Rezoning Transportation Analysis

Petition Number: 2020-145

Revision Log:

Date	Description
11-30-20	First Review (LJ)
12-28-20	Second Review (LJ)
01-26-21	Third Review (LJ)
02-08-21	Fourth Review (LJ)

RZ-2

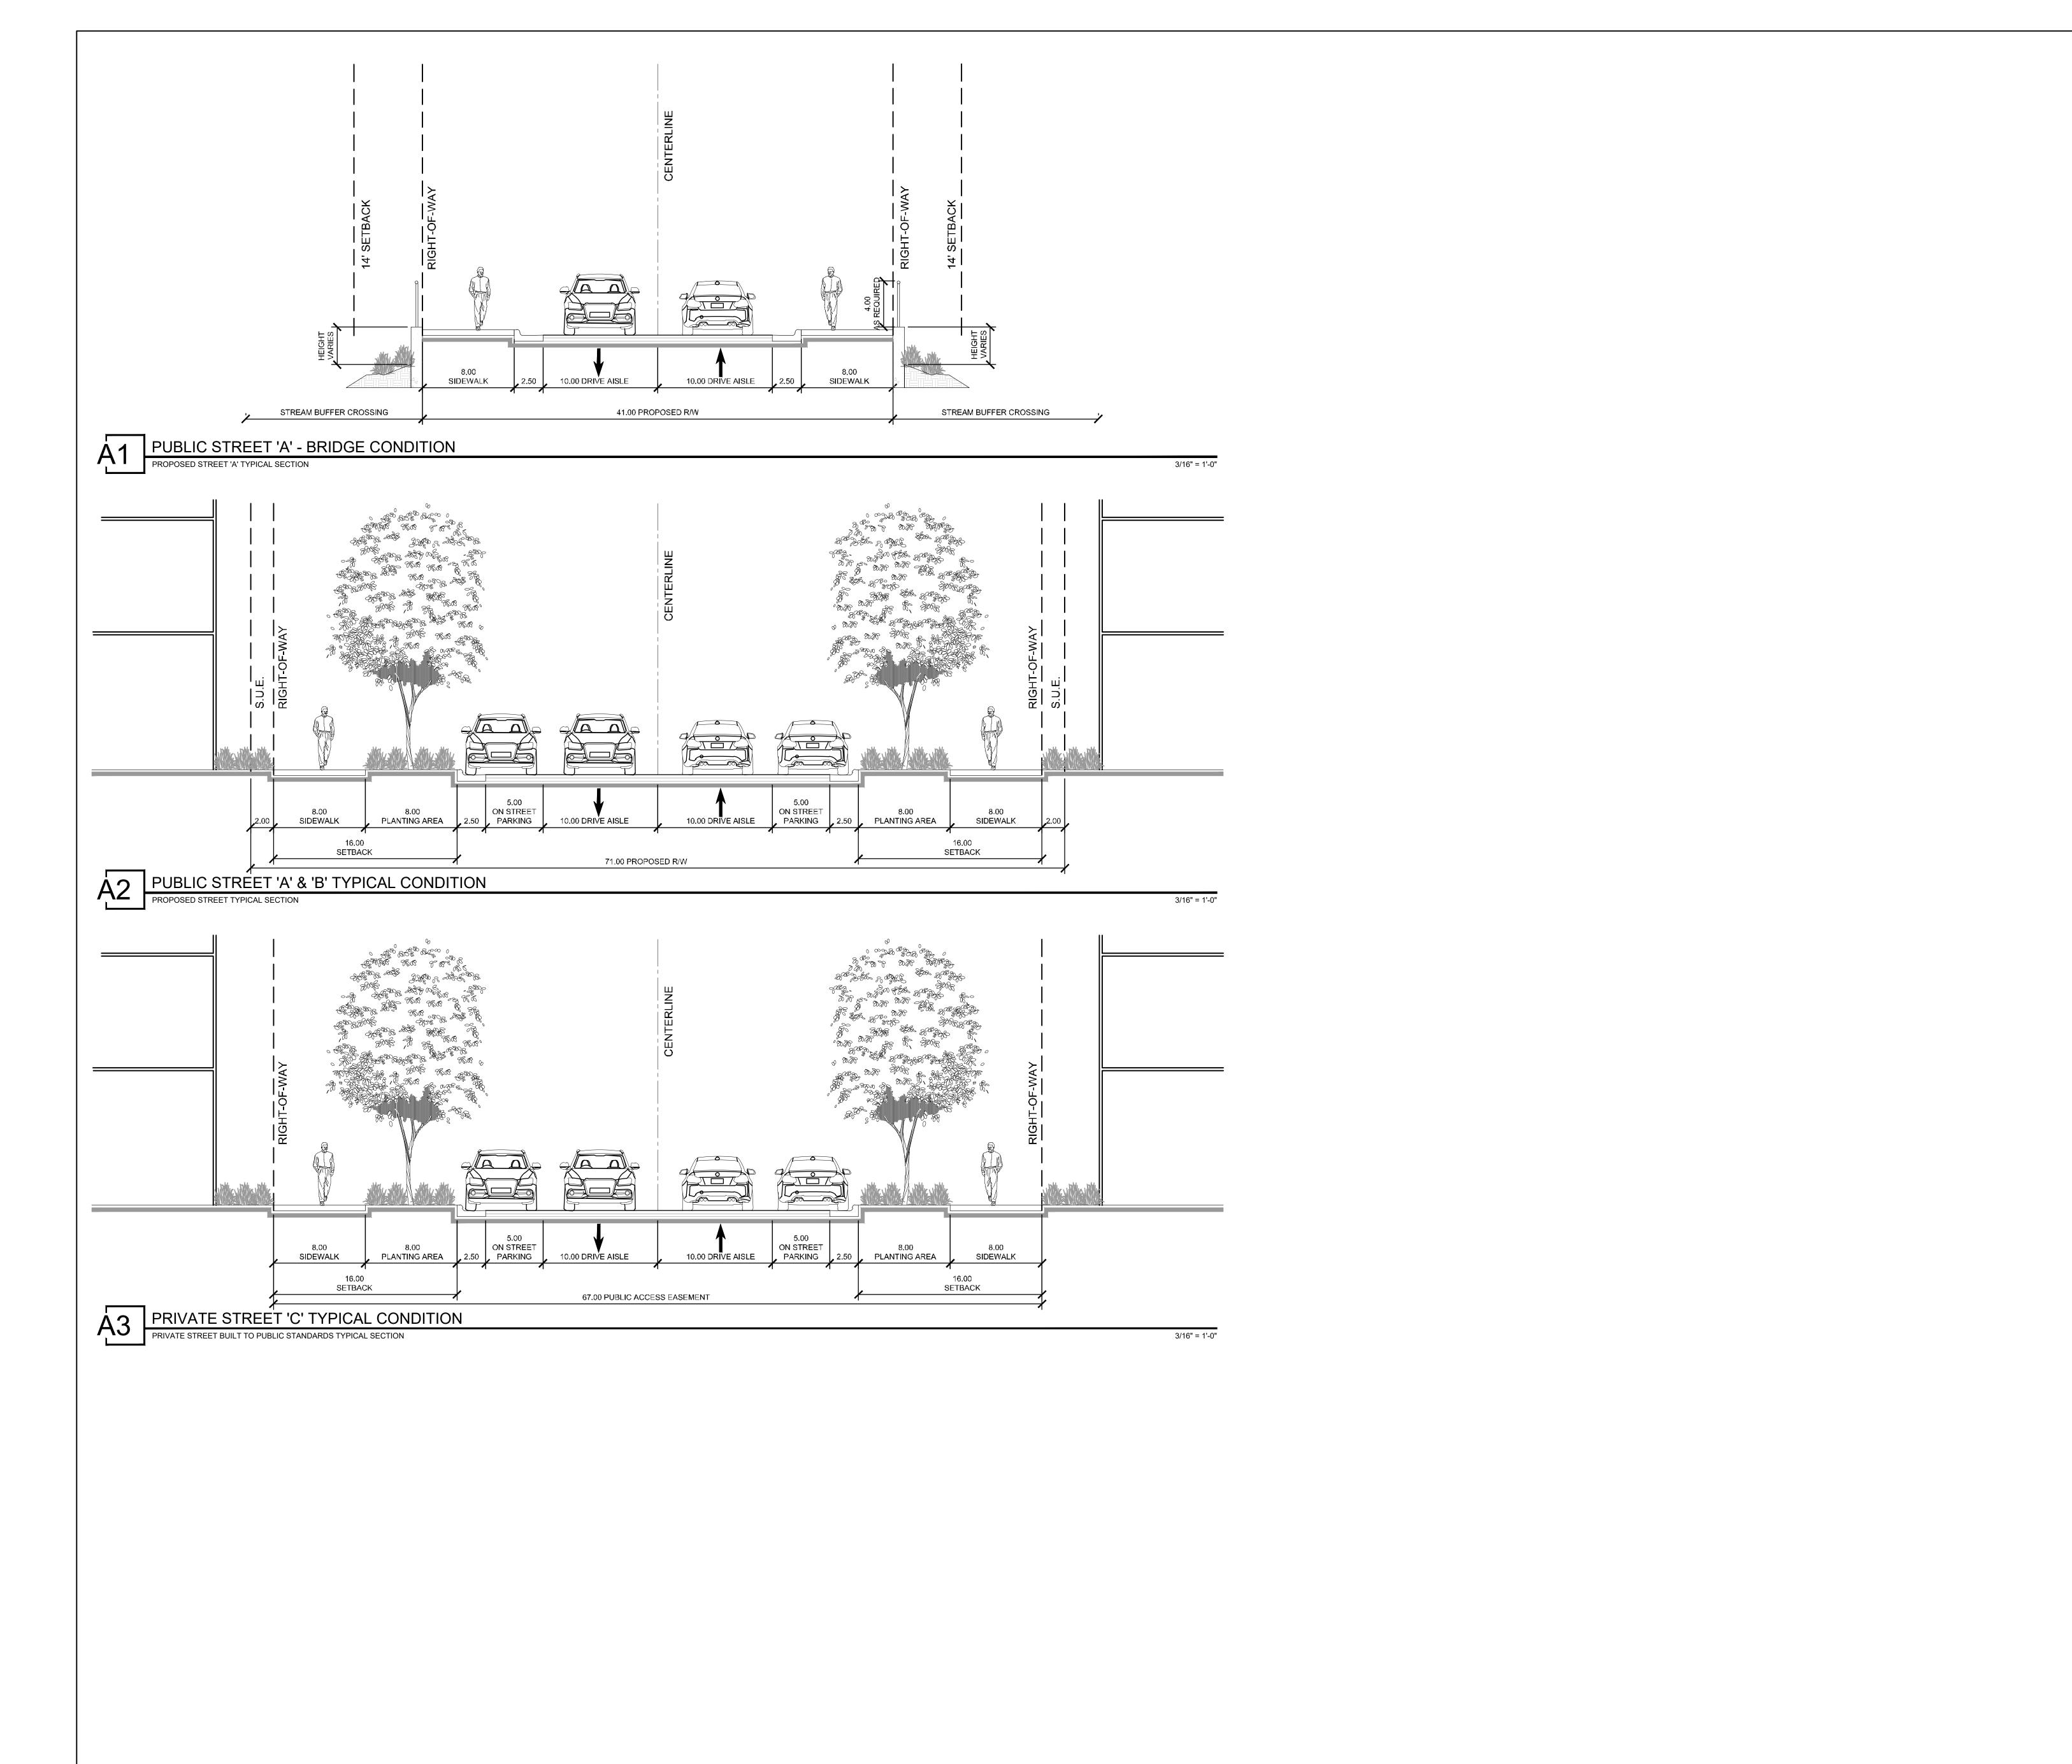
9. ~~**NEW COMMENT (01/26/2021):** Petitioner shall remove note, III. Transportation, 5. f.~~
